Cottam Solar Project

The Applicant's Cover Letter for Responses to the Secretary of State's First Request for Information

PINS reference: EN010133

Document reference: DEC/C8.1.40

Drawing file: EN010133 / EN010133-001019-C6.4.8.16.5_A Figure 8.16.5 Landscape and Ecology Mitigation and Enhancement Plan - Cottam 1_South_Sheet 2.pdf

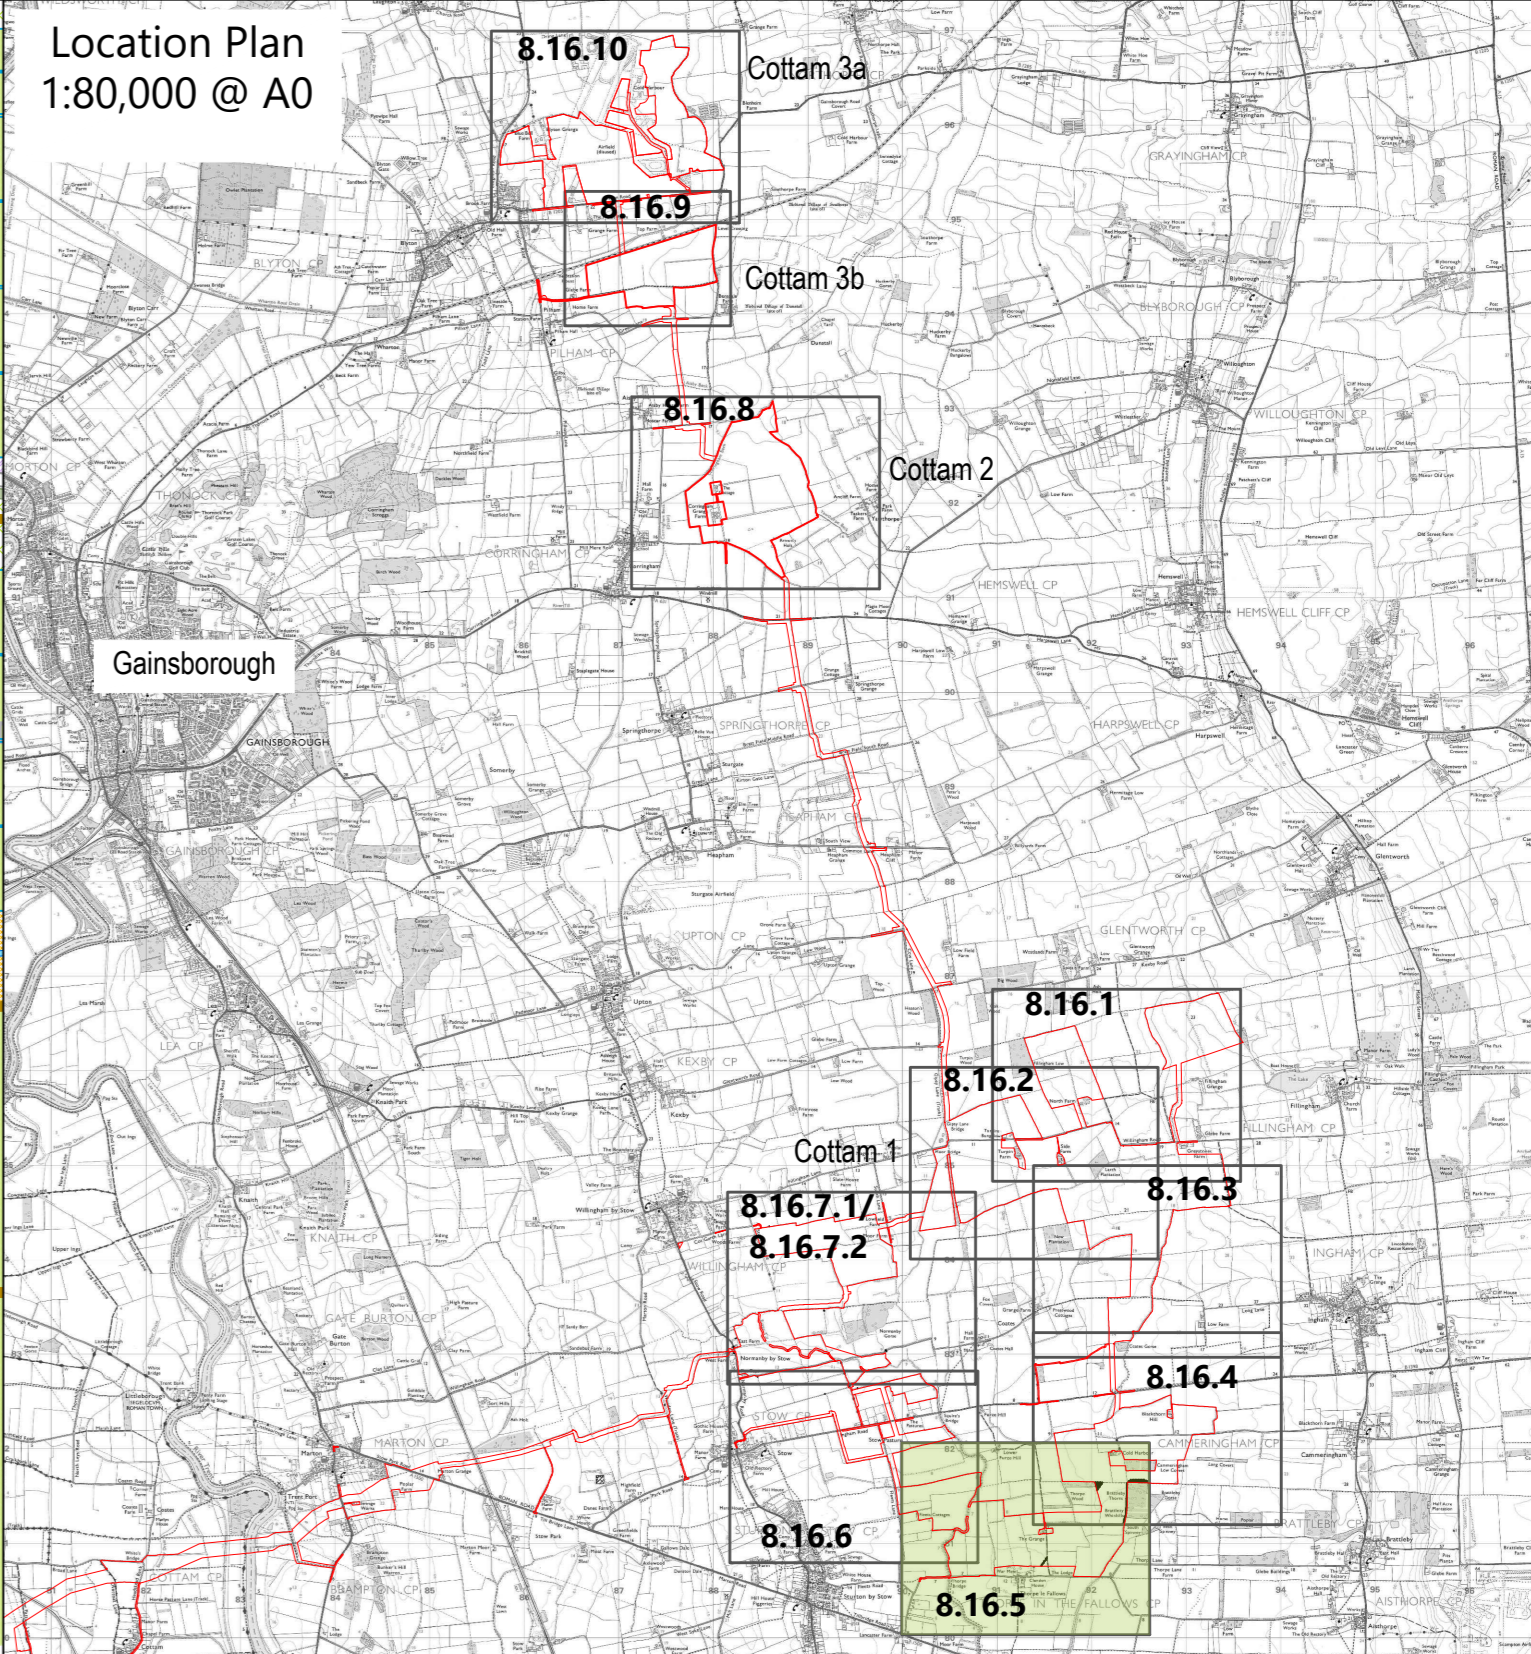
Additionally, a revised version of Cottam 1 South Sheet 2 of the Landscape and Ecology Mitigation and Enhancement Plan ("LEMEP") [DEC/C6.4.8.16.5_B] has been submitted, showing the removal of the solar array area as requested, and the proposed planting of the historic boundary as a hedge formed of native tree species.
